Environmental Health Division
1675 W. Garden of the Gods Road
Suite 2044
Colorado Springs, CO 80907
(719) 578-3199 *phone*
(719) 578-3188 *fax*
www.elpasocountyhealth.org

Crystal Park Site 93, 565 Sunrise Peak Road, CP-18-010

Please accept the following comments from El Paso County Public Health regarding the project referenced above:

1 SITE
SCALE: 1" = 10'-0"

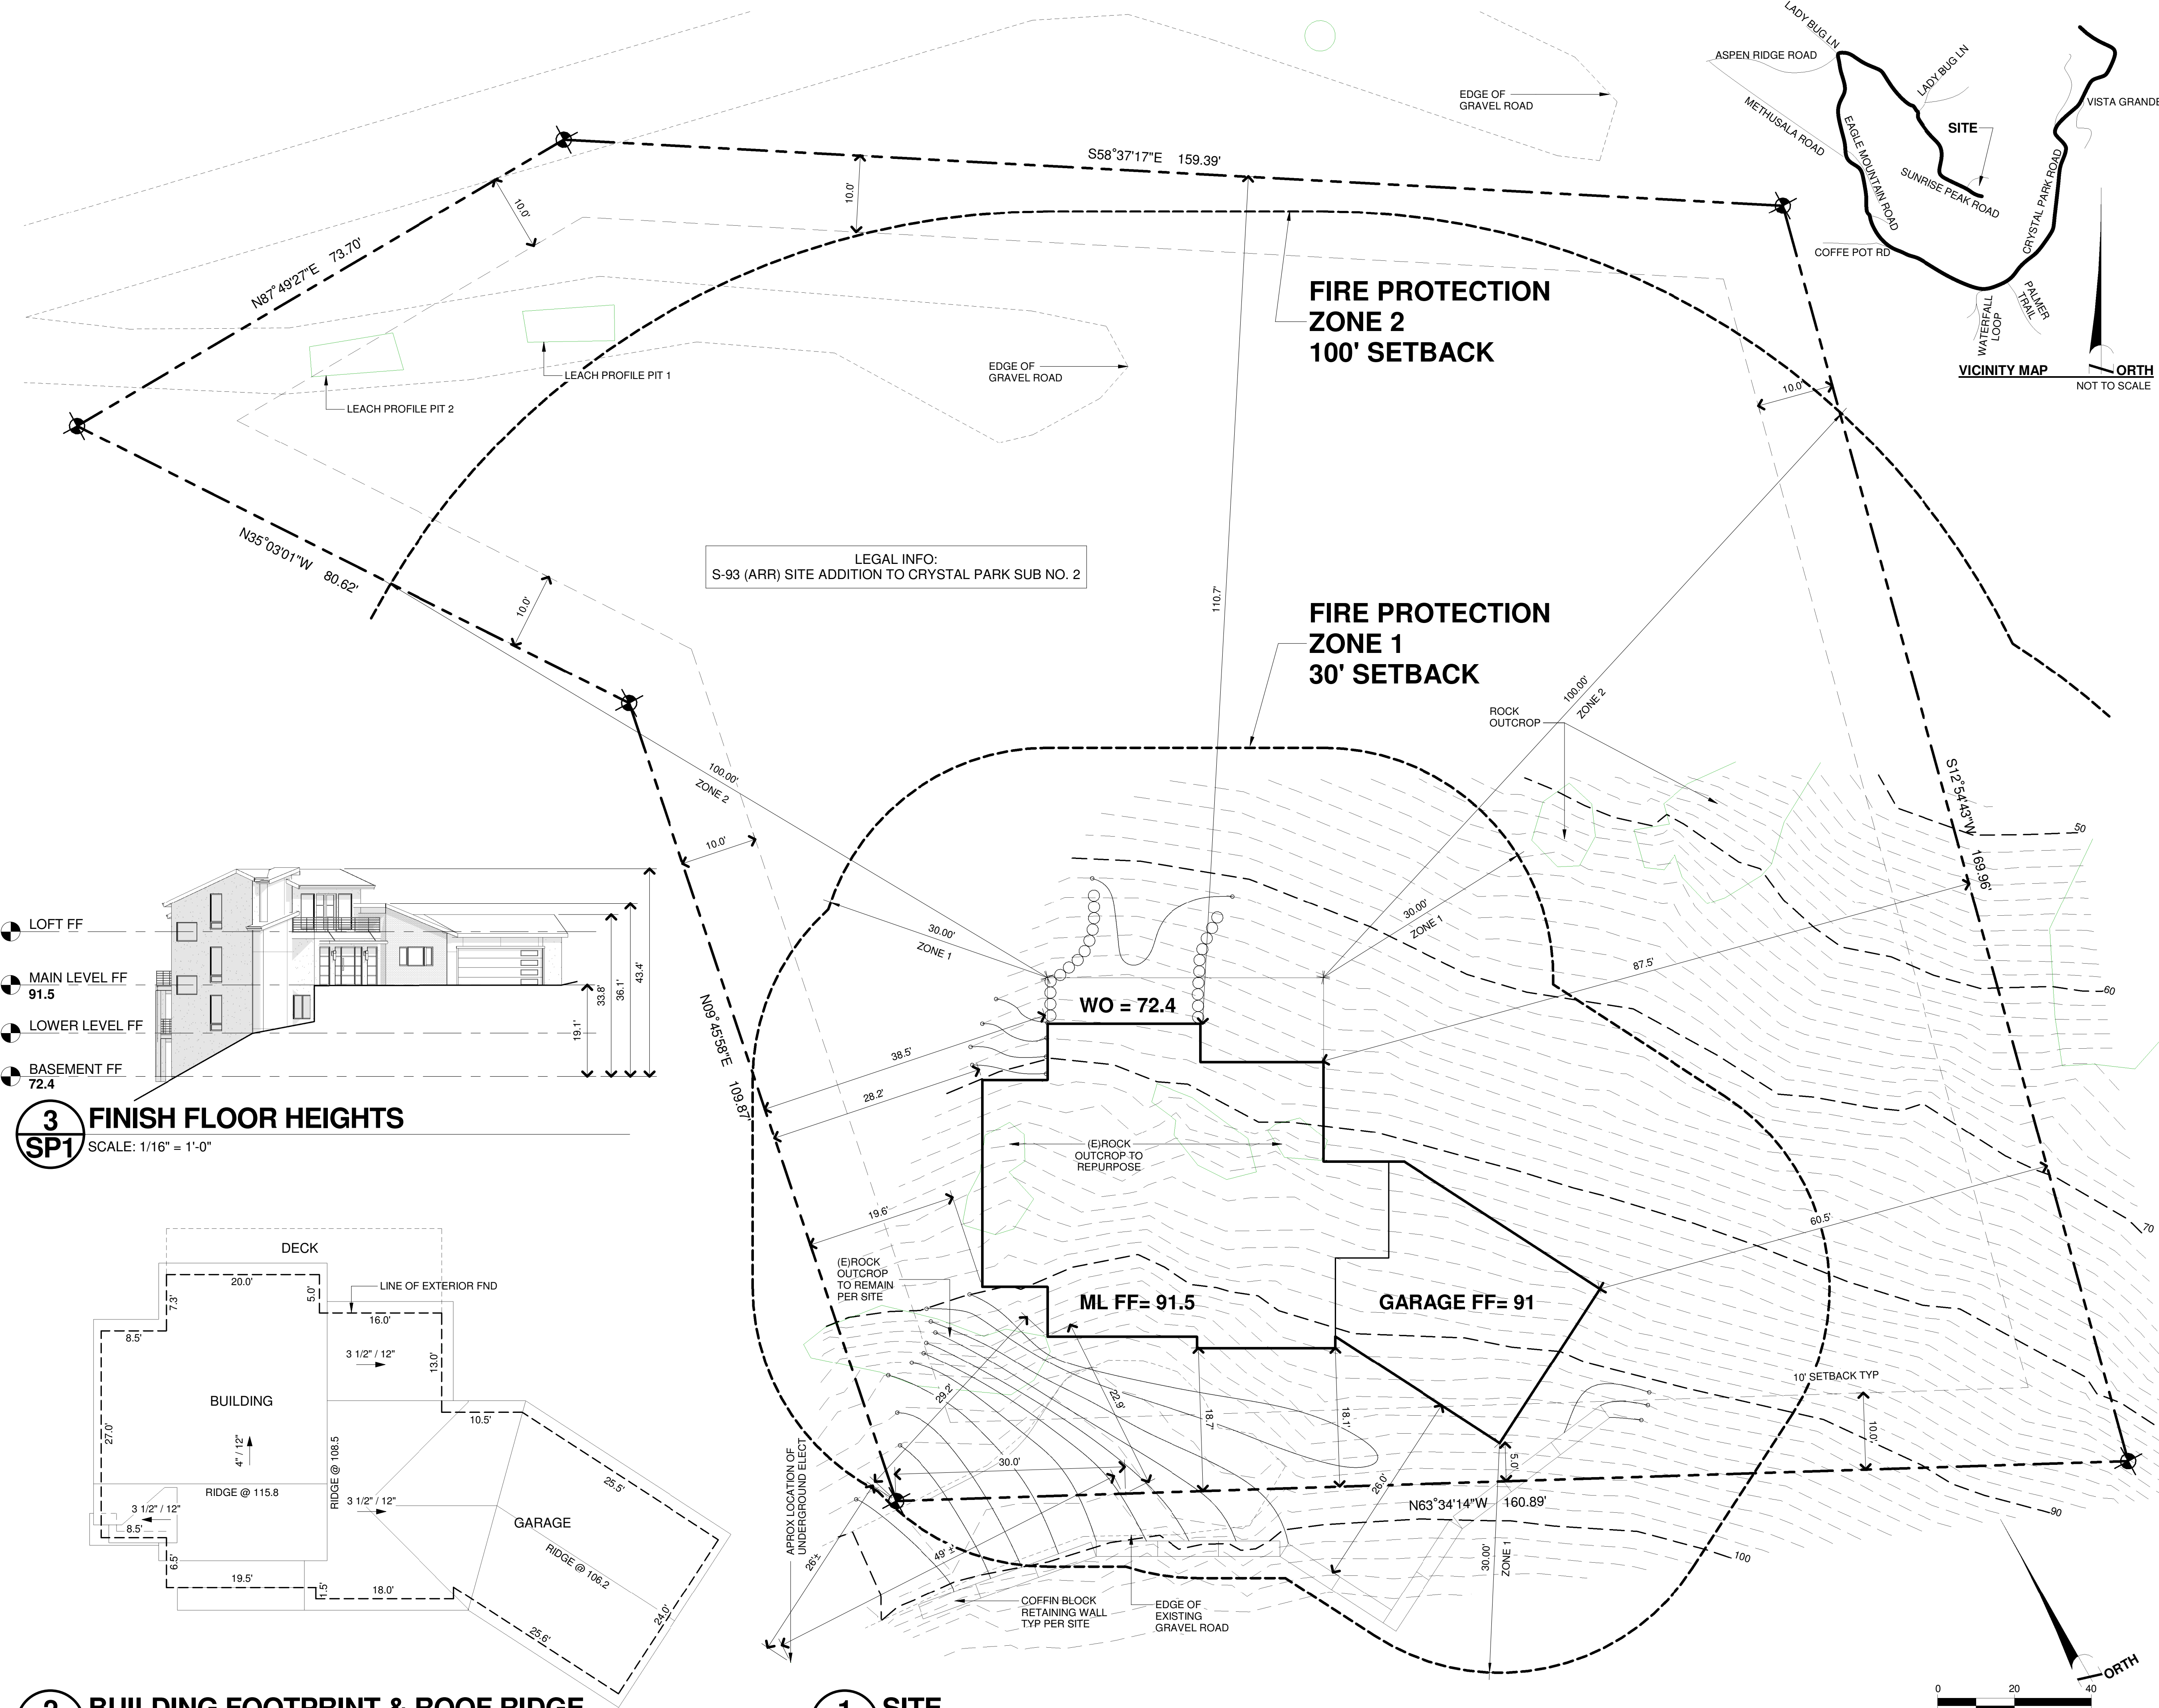
- **Crystal Park Site 93, 565 Sunrise Peak Road, is a residential development site with water from an individual private well and wastewater service by an on-site wastewater treatment system (OWTS).**
- **The site development plan indicated where 2-soil profile test pit excavations holes were located on the NW area of the Site Development Plan, but the test results were not included in the RMG Engineering or Geoquest Engineering Soil Reports.**

El Paso County Public Health requires a New Onsite Wastewater Treatment System (OWTS) Permit to be issued prior to lot development. The OWTS must meet all current El Paso County Public Health OWTS Regulations, including meeting the minimum installation setbacks of the well to all components of the OWTS. NOTE: The location of the well was not on the Site Development Plan, so be aware of the requirements.
